Transport Assessment

State Significant Development Application – Modification

657-769 Mamre Road, Kemps Creek (SSD-9522) Modification

TABLE 2 RESPONSE TO TFNSW COMMENTS – EMAIL OF 3 NOVEMBER 2021

TUNNING PATHS PLAN-LOT 2 ACCESS
SCALE 1:300

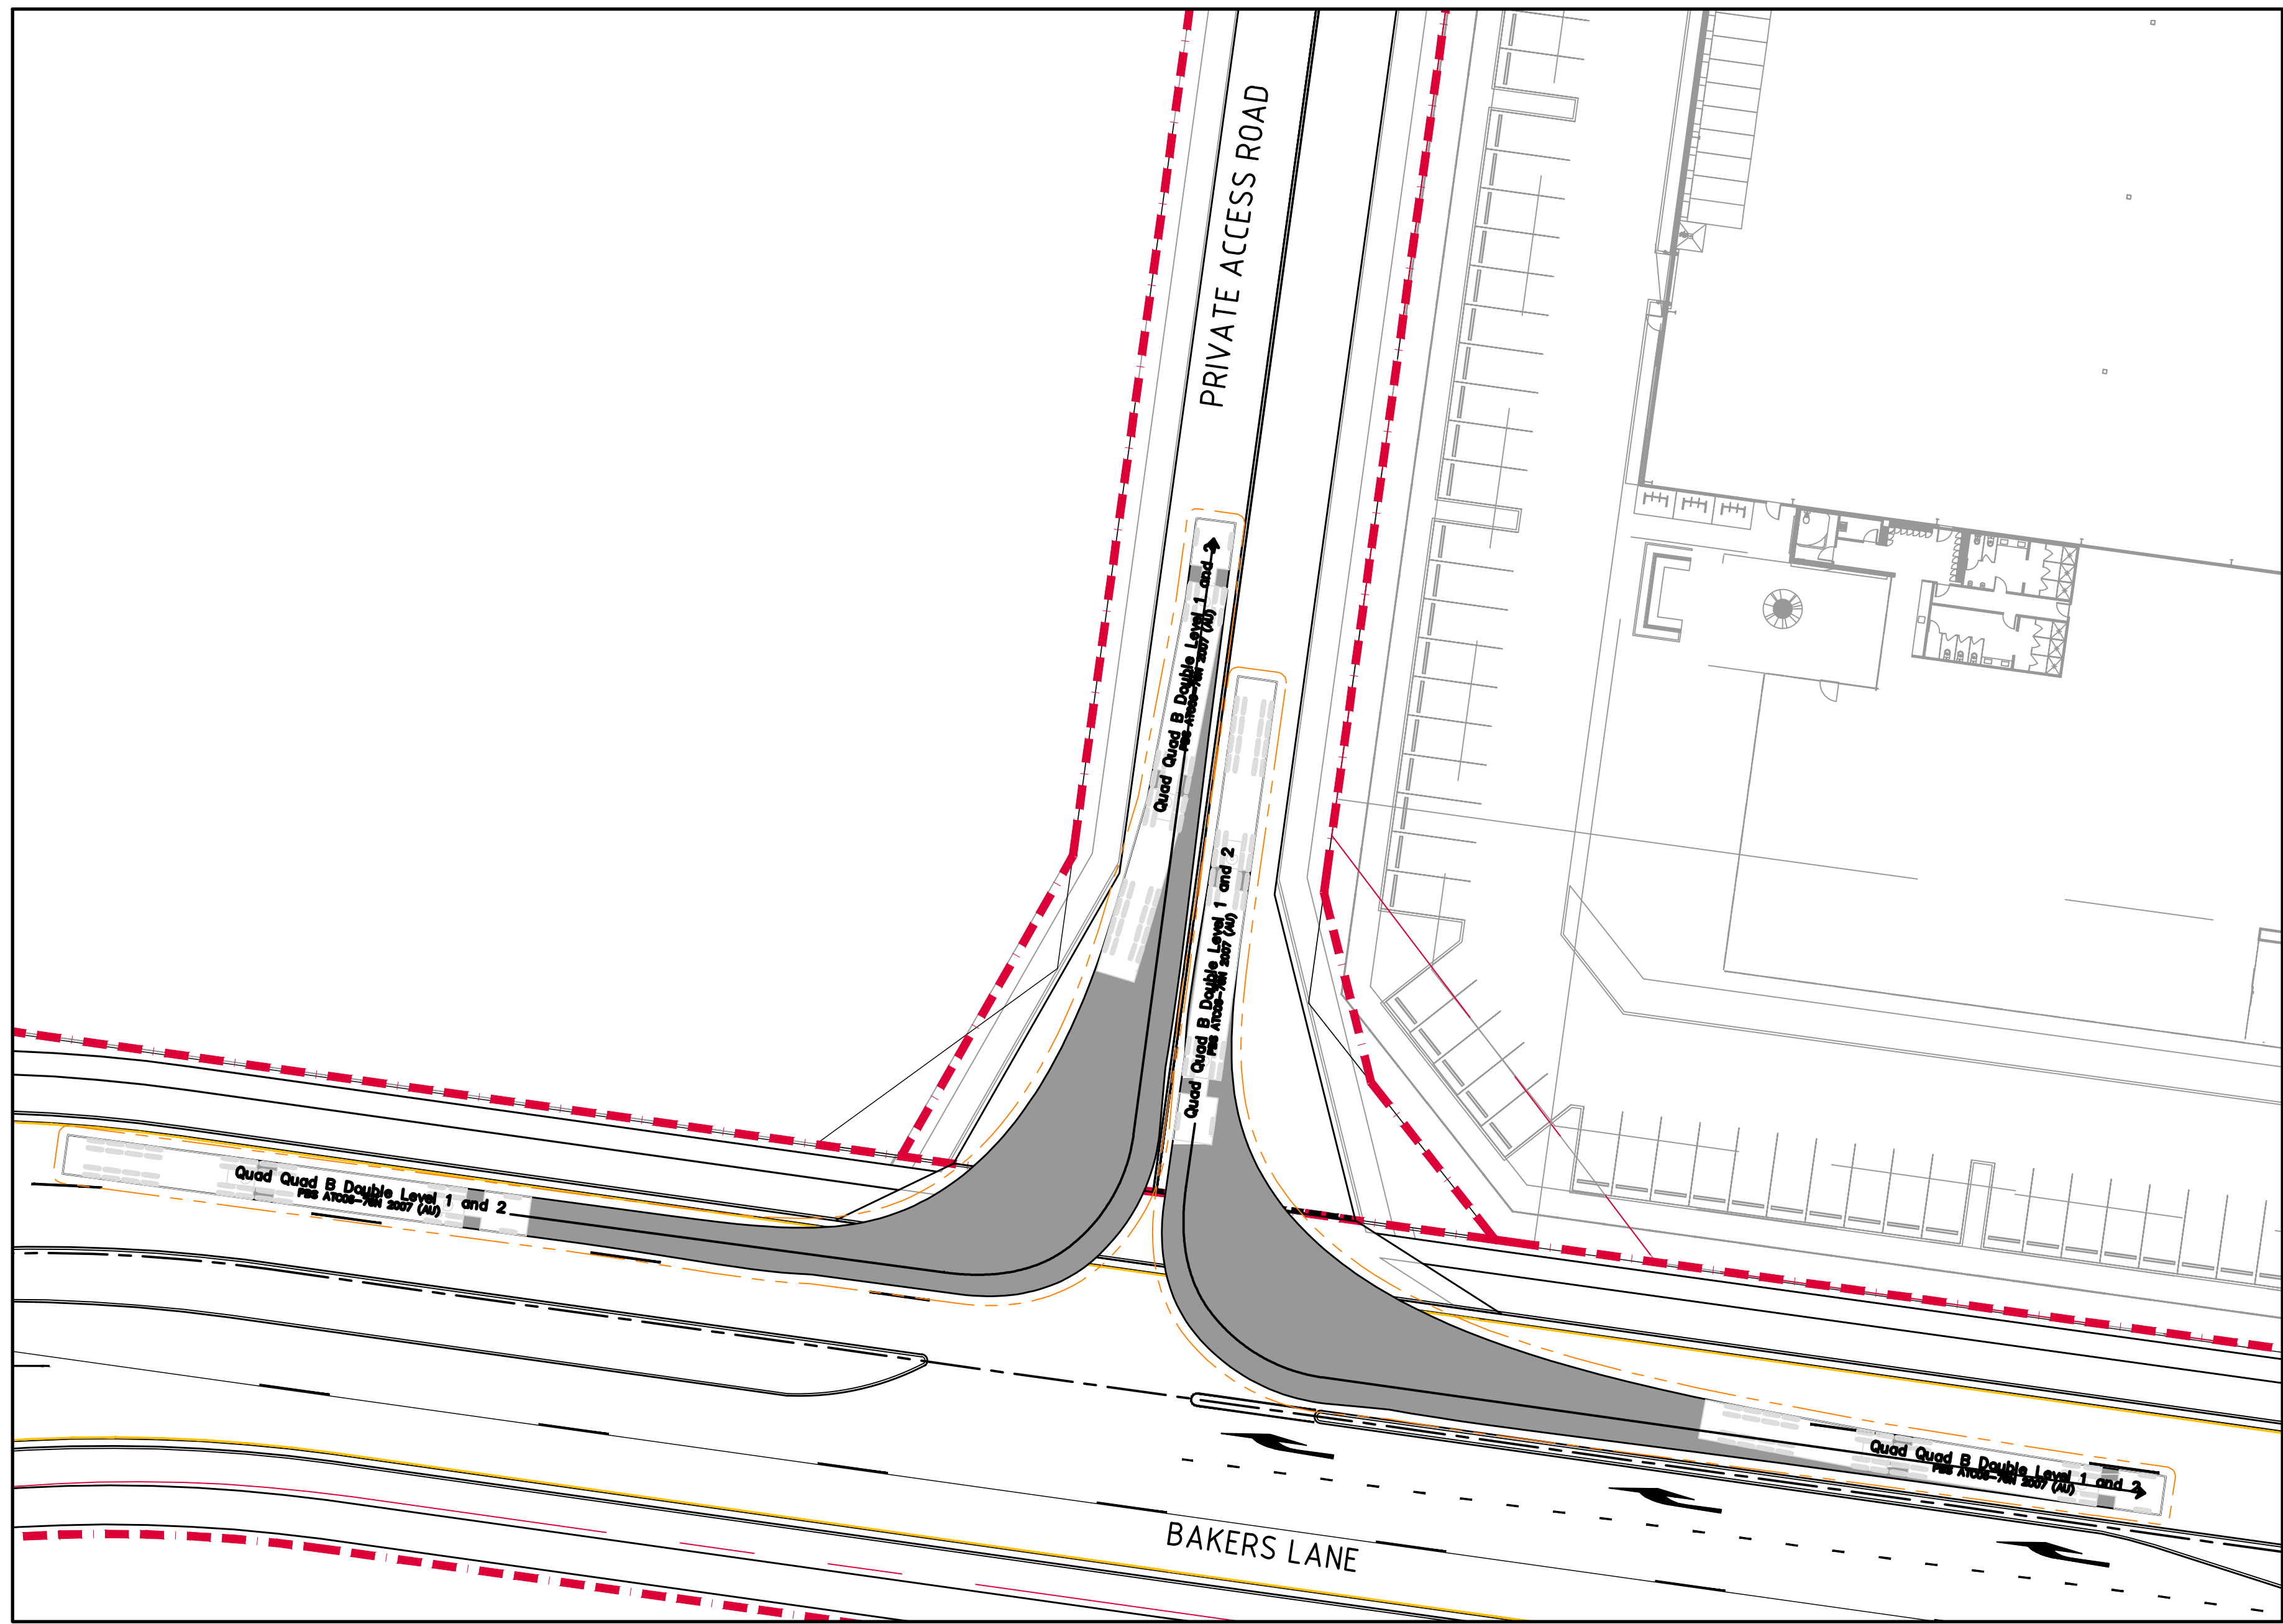
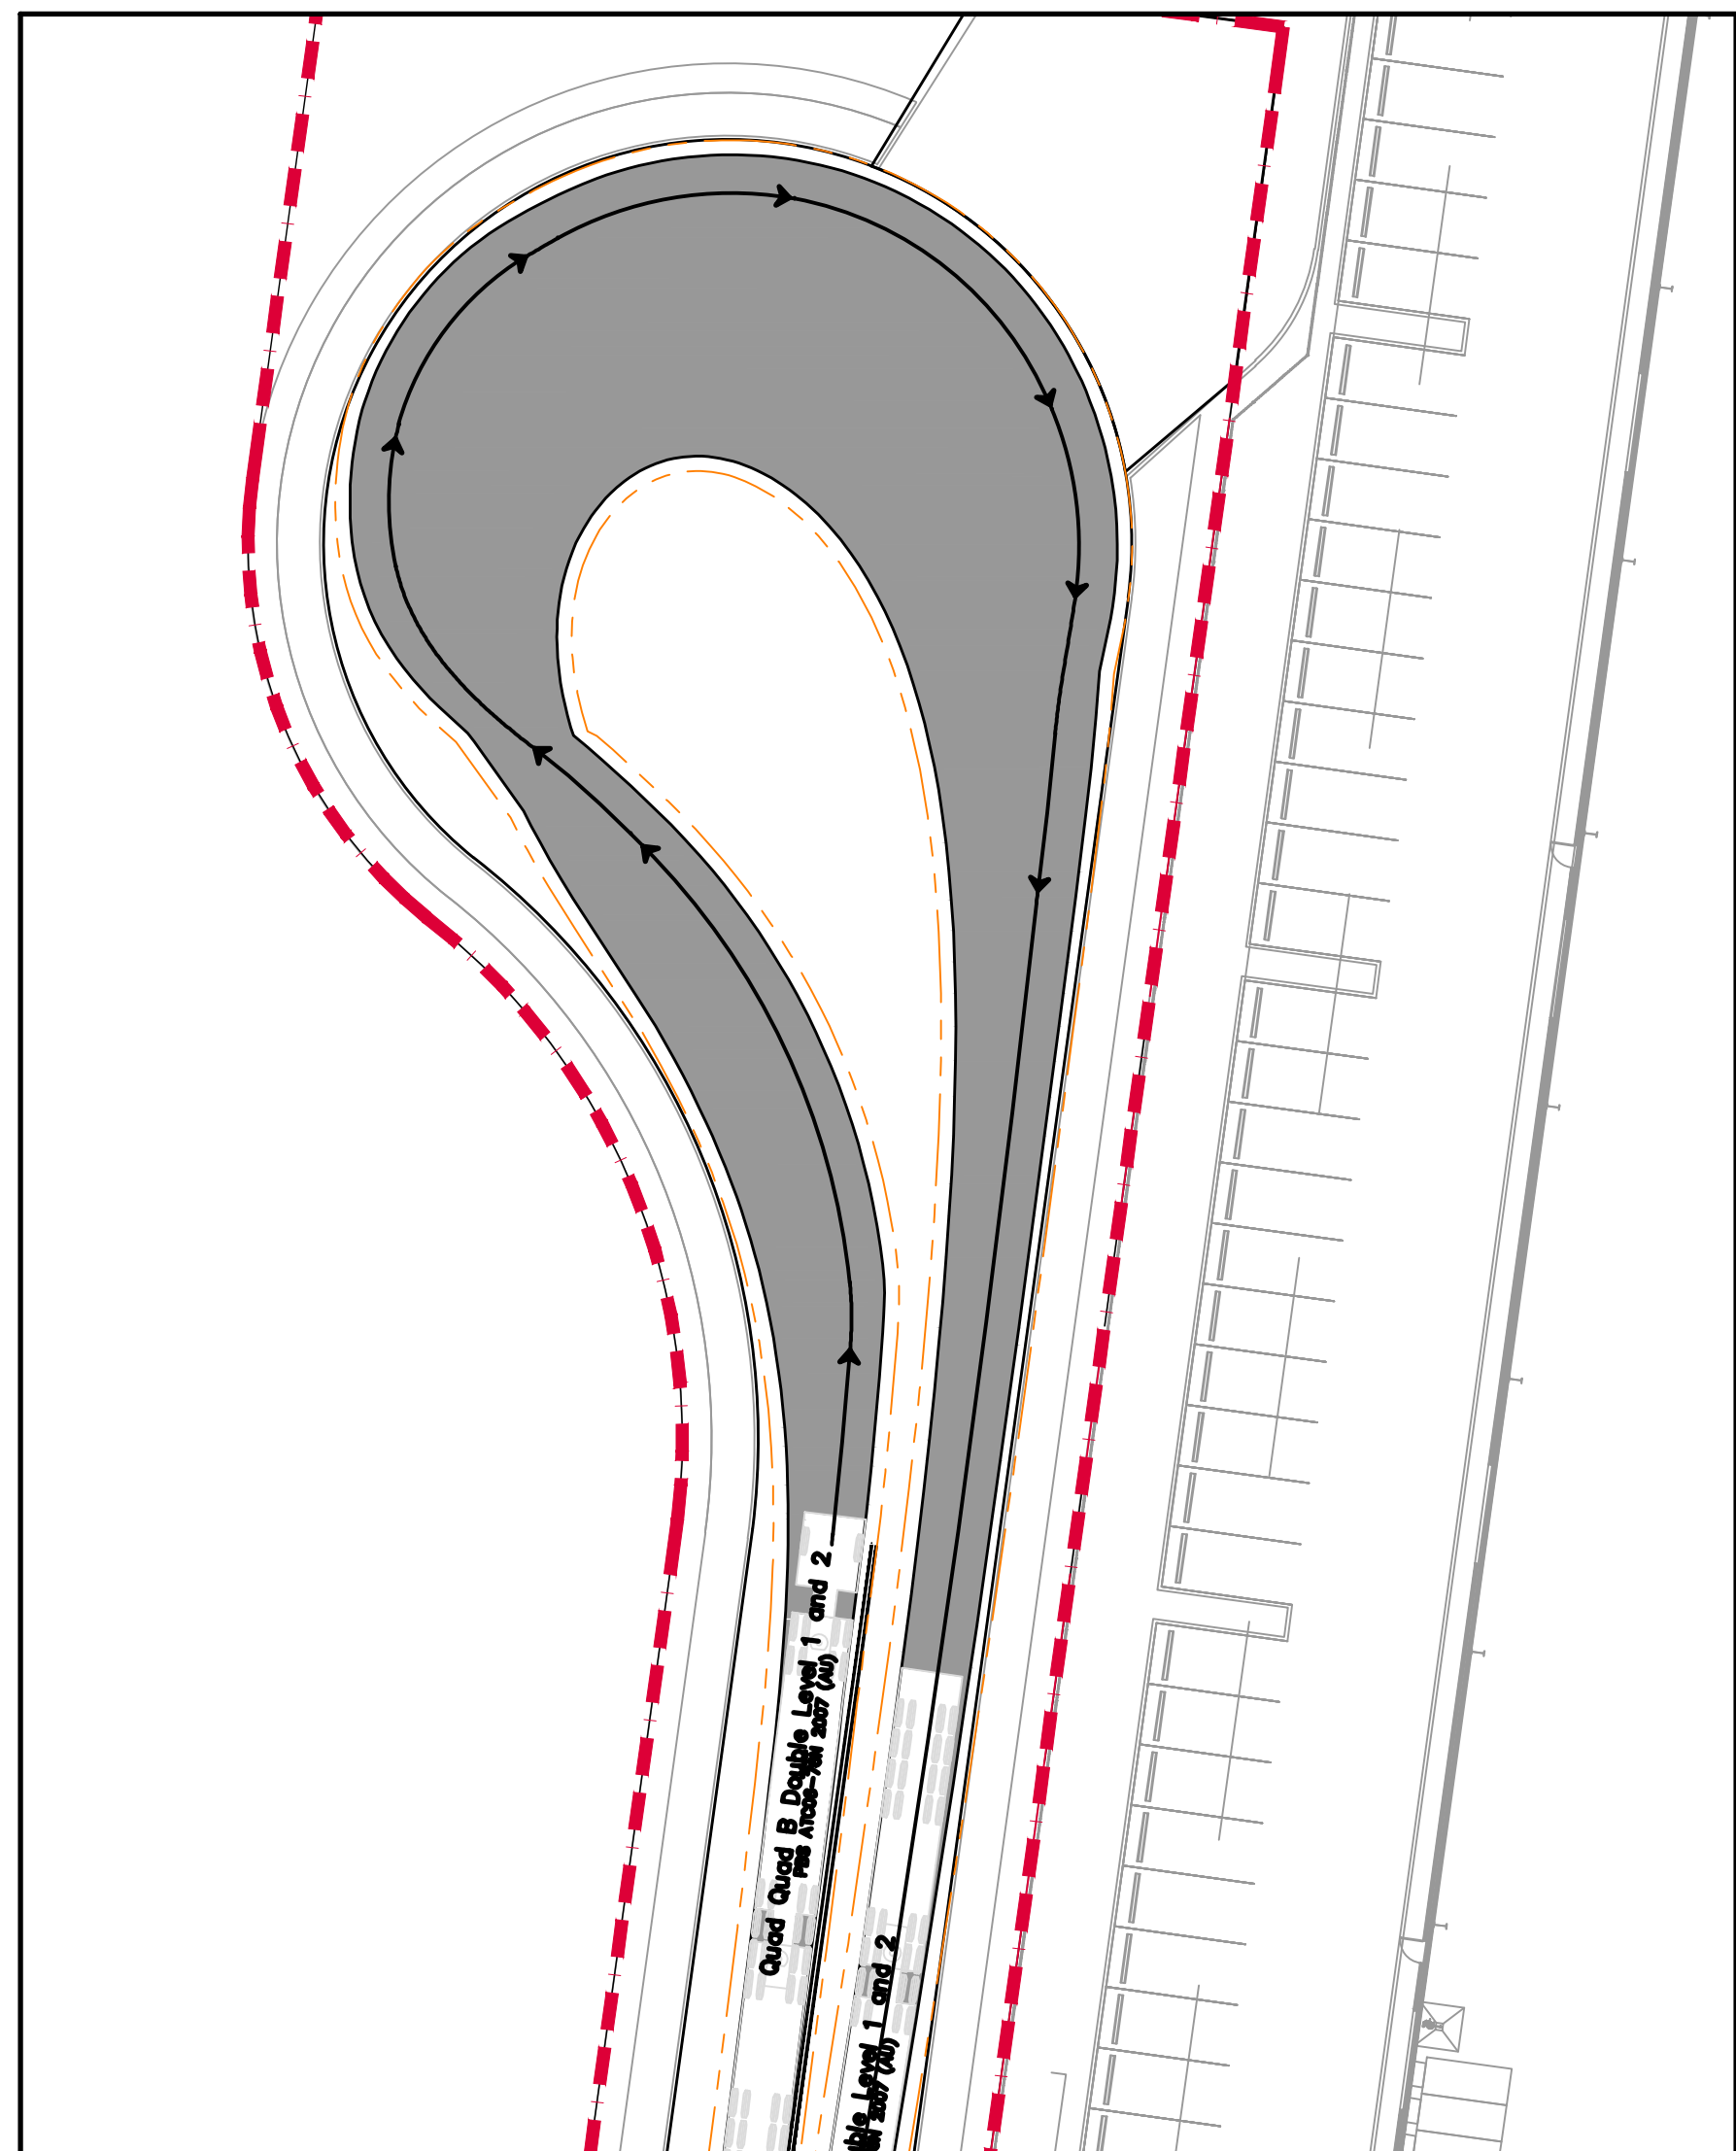
- 3 Access closest to Mamre Road – in order for a 26m B-double to undertake the turn they would need to undertake the turn from the wrong side. Any access to should be able to accommodate for simultaneous entry/exit.

It is important to note that this access point is a heavy vehicle exit point only for Lot 2 (which does NOT ACCOMMODATE ENTRY movements). Therefore, 26.0m B-double trucks will not undertake entry movements for Lot 2 (from this access crossover). Based on the swept path analysis included in **Appendix D**, this exit movement can occur in a lane correct manner. A reduced copy is also re-produced overleaf.
